From: Tom Errico <thomas.errico@tylin.com>
To: Jean Fraser <JF@portlandmaine.gov>
CC: David Margolis-Pineo <DMP@portlandmaine.gov>, Katherine Earley <KAS@port...>
Date: 5/9/2014 3:59 PM
Subject: 97 Cumberland Avenue

Jean - The following represents my preliminary traffic comments for the project.

Preliminary Site Plan

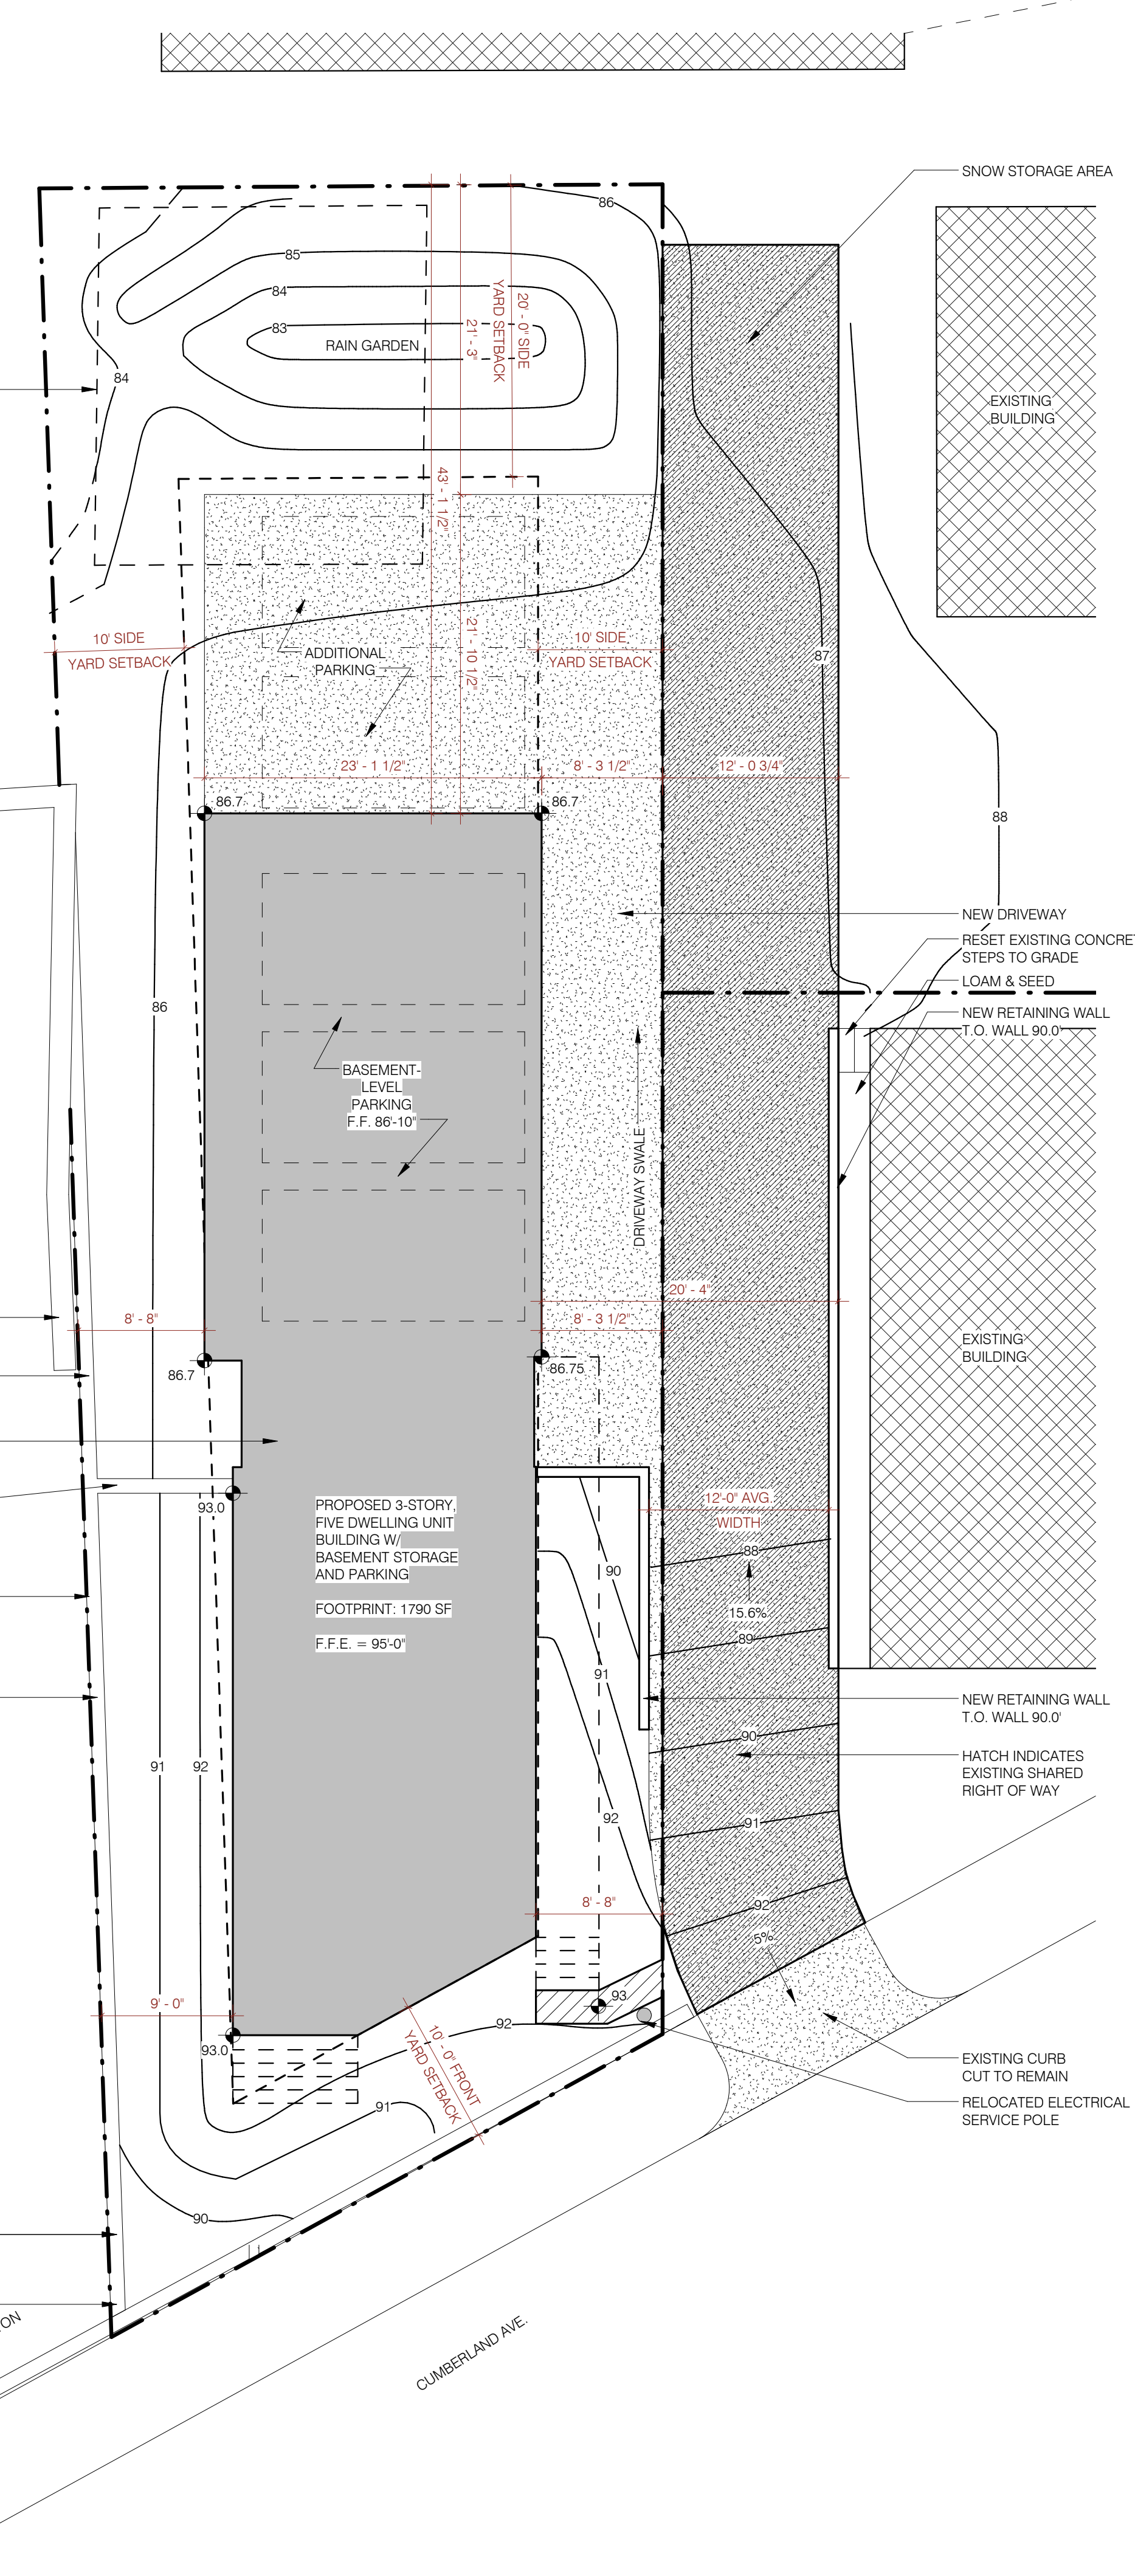
* The proposed driveway is 12-feet wide and meets City standards for a development that has less than 10 parking spaces. Because this determination is based on all traffic using the driveway, and that the driveway appears to have a shared use function, all shared use parking spaces should be included in these determination of width adequacy. Based upon my review, the total number of parking spaces using the driveway is less than 10 and therefore the project is compliant from a width perspective. The applicant should confirm this.

* The aisle width for the garage parking spaces do not meet City standards. The applicant should formally request a waiver from the City's technical standards and provide documentation in support of the waiver request.

* The applicant should confirm that the proposed snow storage area will not interfere with vehicle circulation movements.

* Sight distance measurements from the site drive should be provided.

BRICK WITH BITUMINOUS BASE DRIVEWAY CONSTRUCTION
NOT TO SCALE

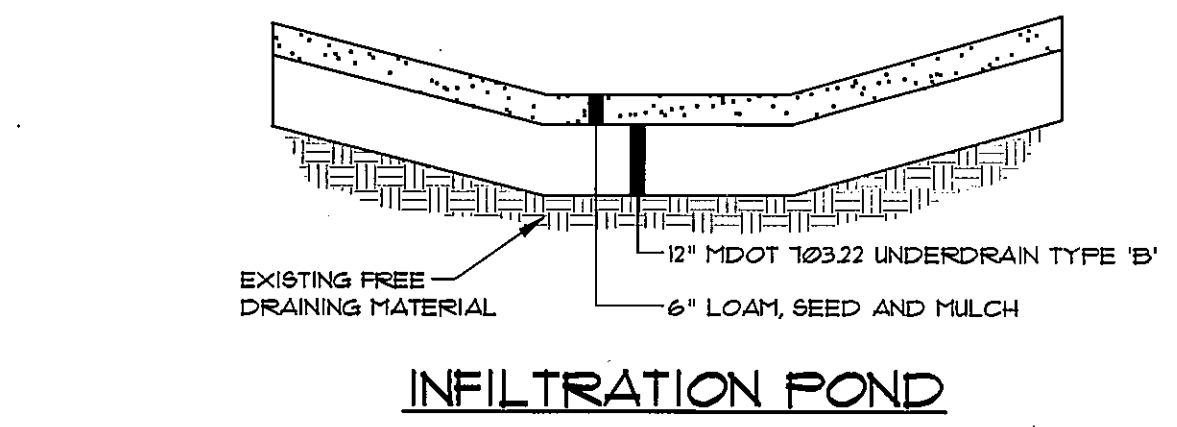
* The driveway apron is proposed to be brick. This does not meet City standards for non-historic districts on the peninsula. DPS will be reviewing this issue.
